High Laithe
Wigglesworth Road
Tossie
Skipton
BD23 4SX

Planning Application No: 3/2020/0955

29th November 2020

Drawing file: planx_downloads / 20_0955_Proposed_Plan.pdf

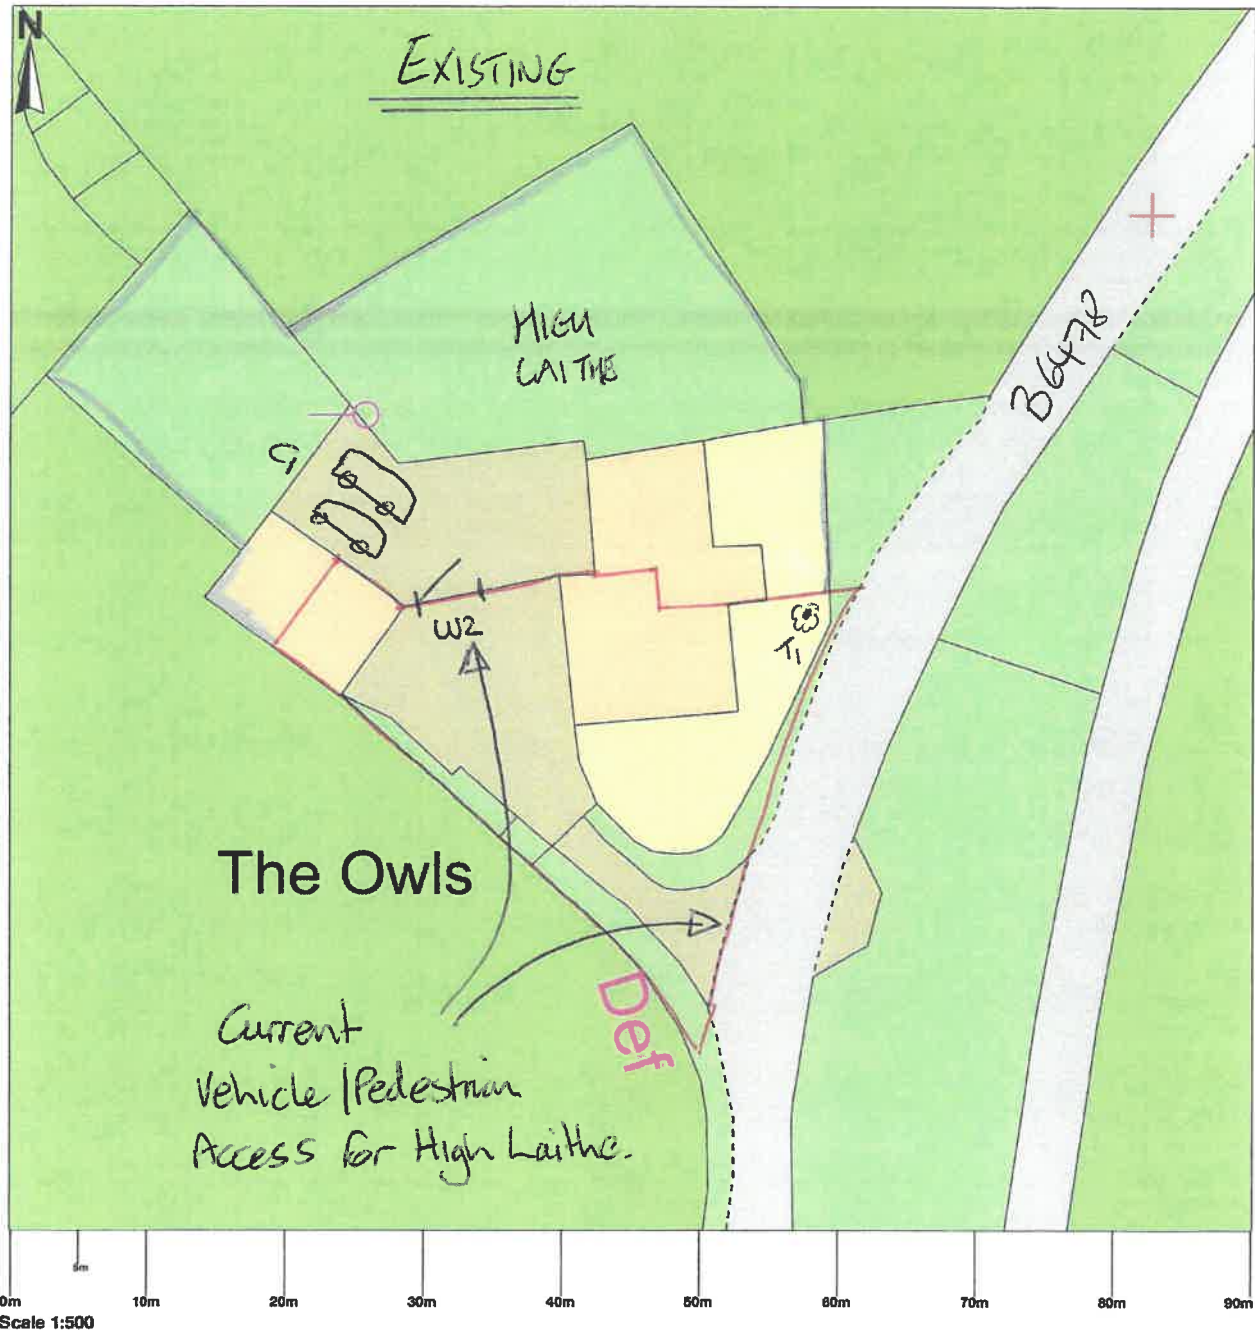
“Access arrangements are to be taken from an unmade length of access track providing access to adjacent agricultural pasture. It should be emphasised that the access track lies beyond the limits of the adjacent adopted highway – managed and maintained by a third party and shown via a submitted location plan to lie outside of the control of the applicant and designated by a blue boundary line.”

This is not the case, we are not planning on gaining access across this track but across what is currently the neighbours garden The Owls. As you will see from a closer inspection on both the Proposed plan and existing plan The Owls boundary extends to the grass verge along the B6478.

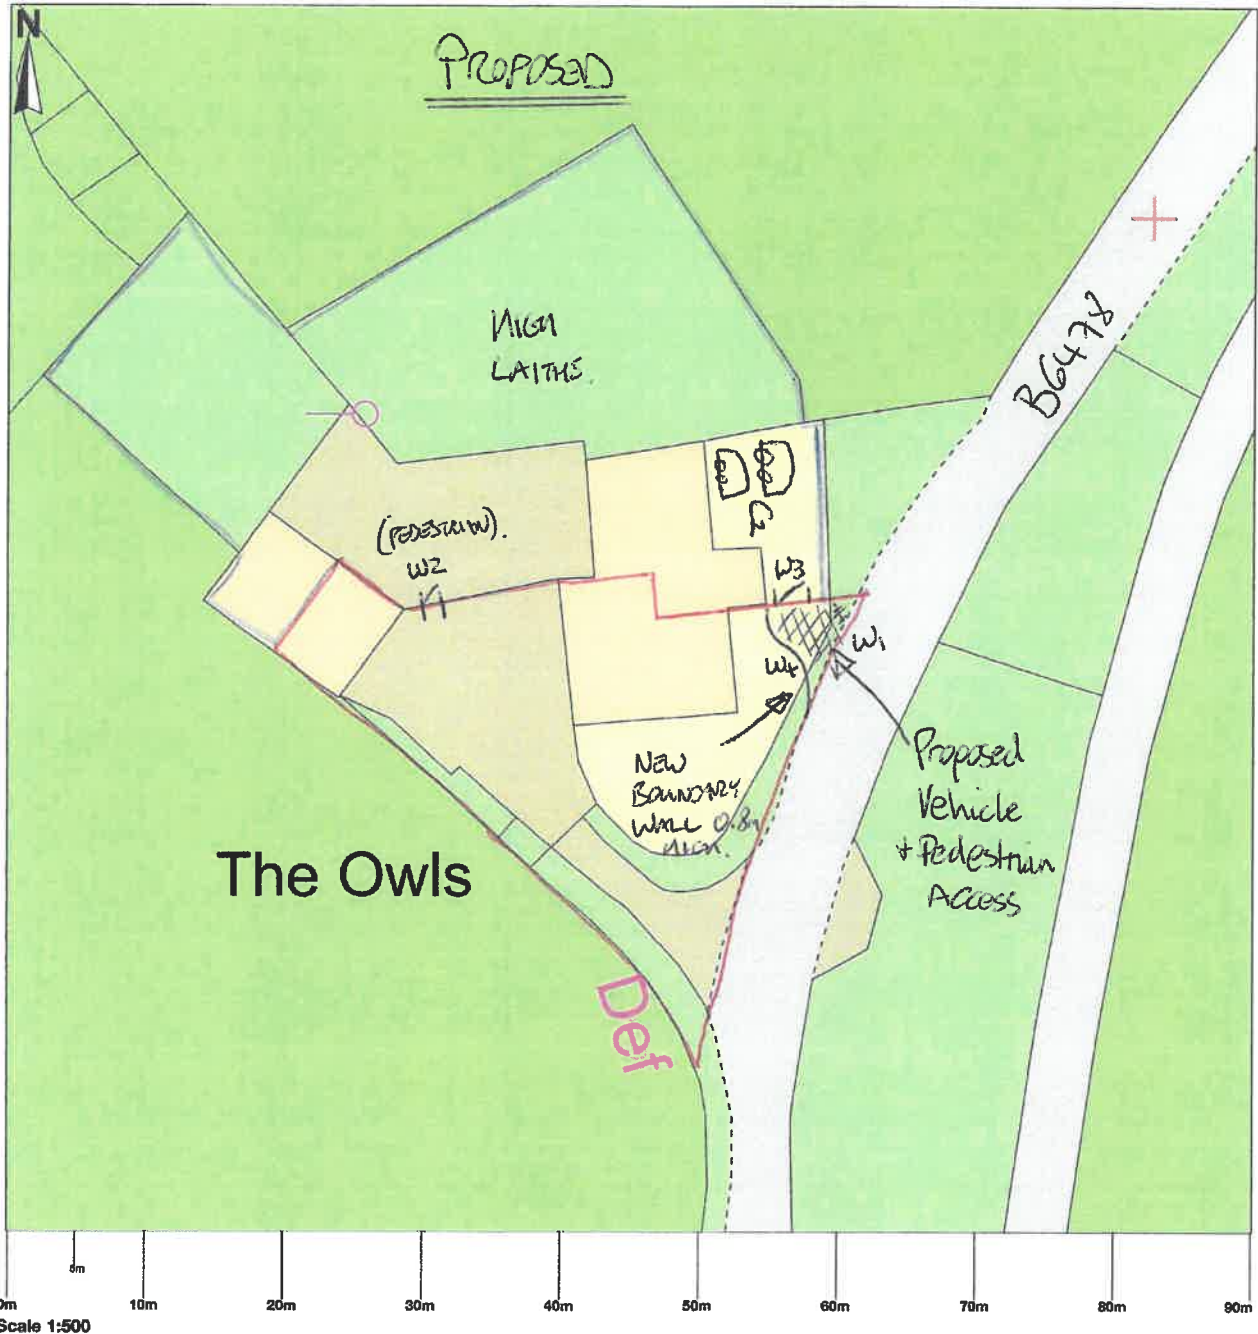
“The submission of a proposed schematic plan indicates construction of an area of hard standing with parking provision for two vehicles. There would appear to be little if any provision for the turning of vehicles within curtilage there by facilitating access / egress from the site using a vehicles forward gear.”

Taking Mr Doran's comments on board we suggest an amendment to the proposed plan to allow for a turning head area of approximately 8m x 10m to be added (area A). Please see “Proposed Plan 2.0 “. This would allow ample provision to turn two vehicles with the curtilage.
